PLANNING CONSULTATION RESPONSE

Application No	2025/0850
Proposal	Erection of 3no dwellings (Outline with all matters reserved)
Address	Land adjacent 2 Cemetery Road, Bolton Upon Dearne, Rotherham, S63 8LS
Date of Consultation Reply	10/06/26
Consultee	Highways DC

Plan 2 Tree Constraints Plan showing the proposed layout

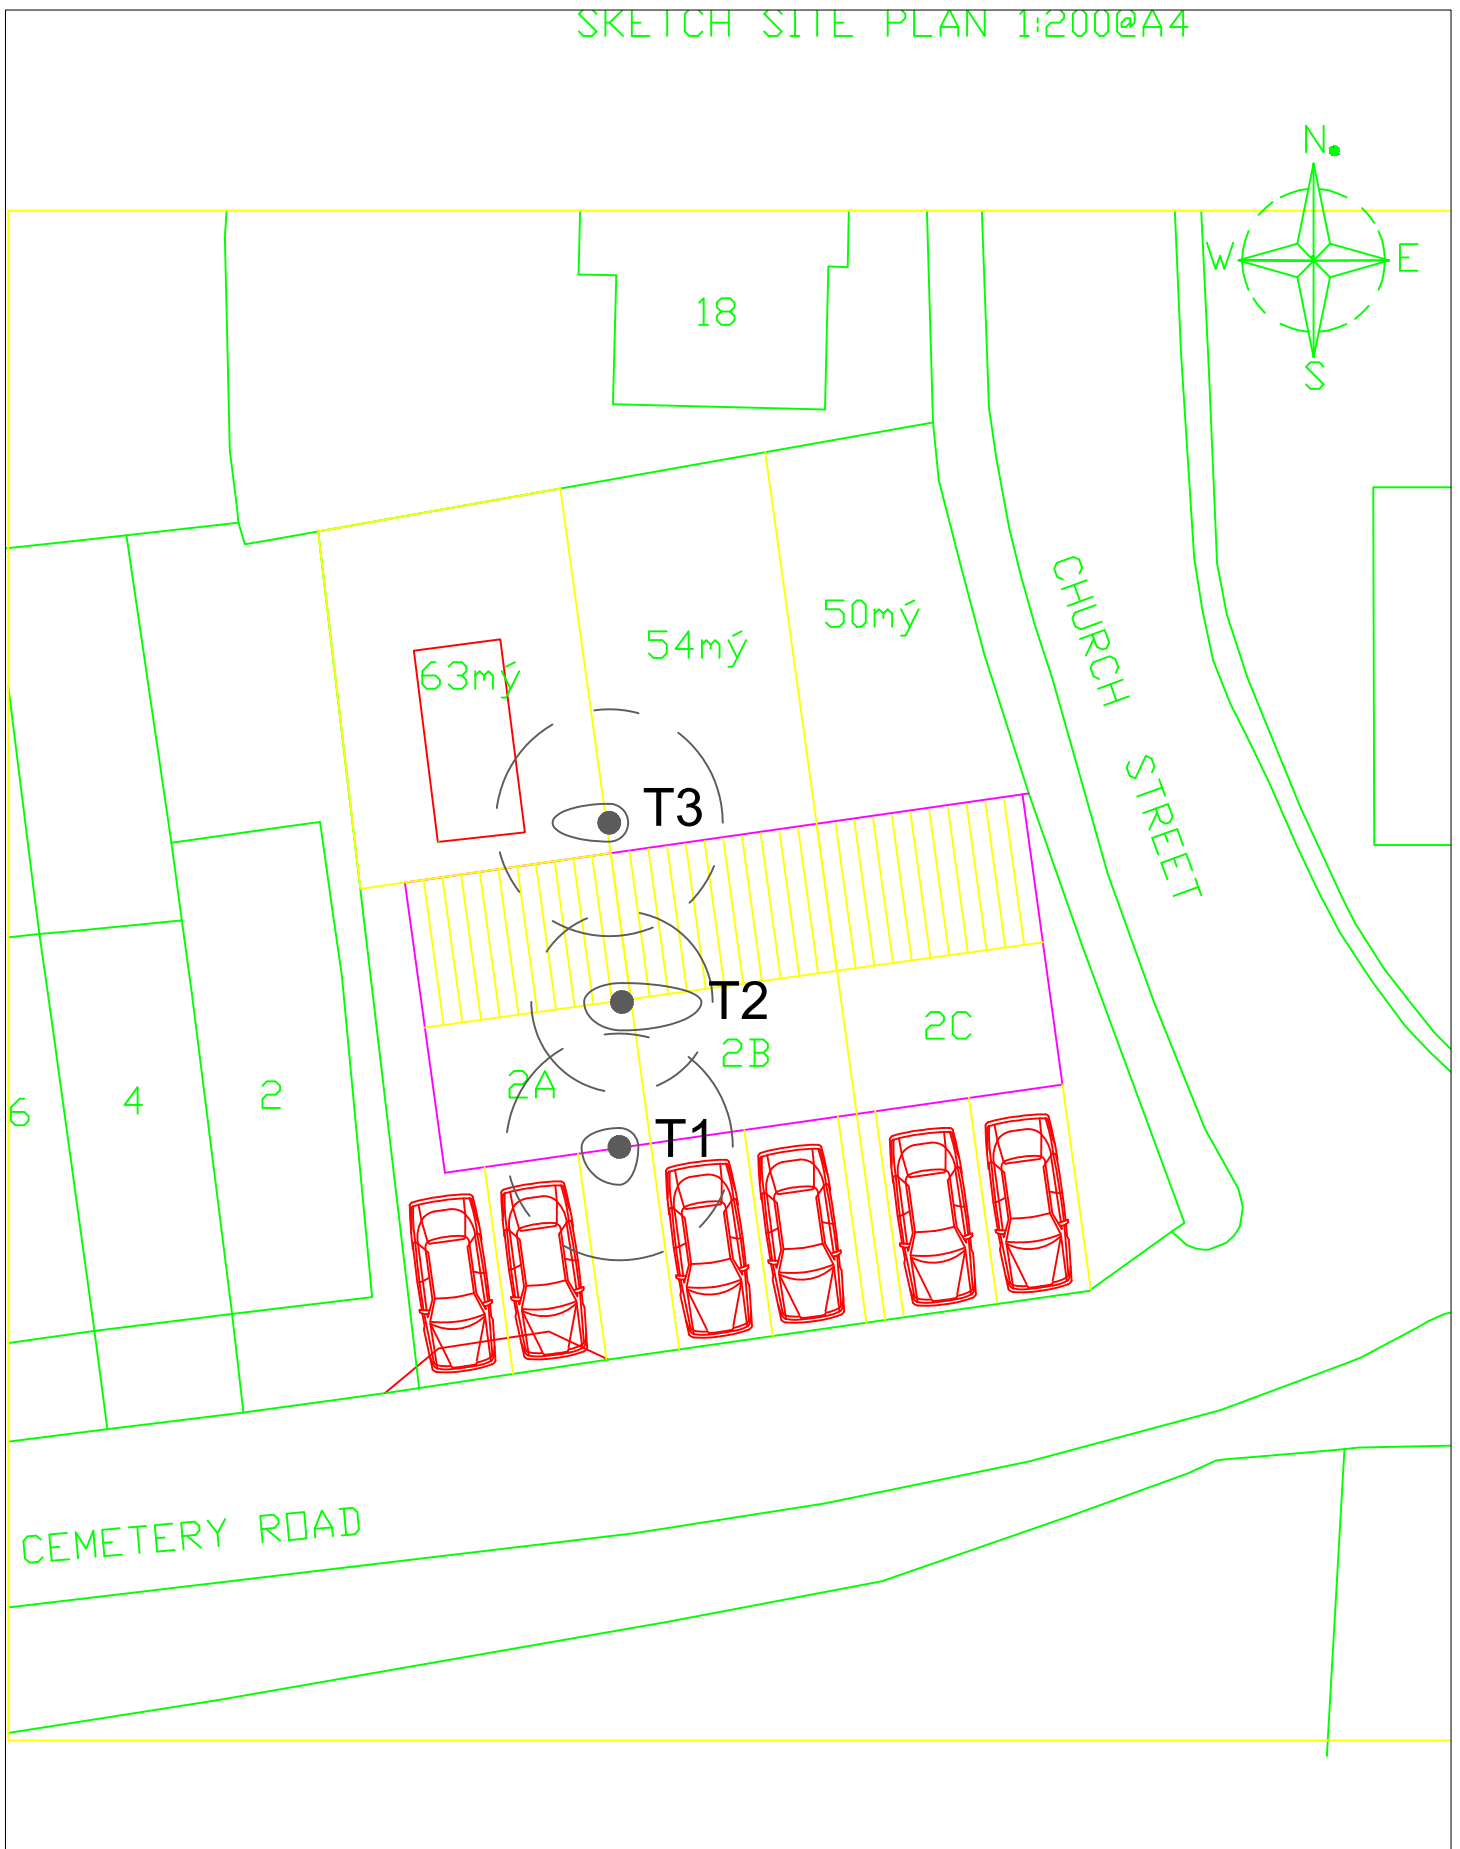
The proposed new dwellings would be built within the amenity space of 2 Cemetery Road. At this outline stage two off-street parking spaces are demonstrated for each property, and this would appear to be acceptable for the size of dwelling proposed.

- There is a footway that terminates at the junction of Cemetery Road and Church Street. This should be continued along the full frontage of the site at a minimum width of 2.0m. This is to allow for statutory undertakings to be installed away from the live carriageway and also to improve pedestrian safety for visitors and residents. The carriageway width should not be reduced.

- Lighting column no. 12 will require relocation. This should be agreed with the Council's street lighting department prior to any approval being granted.
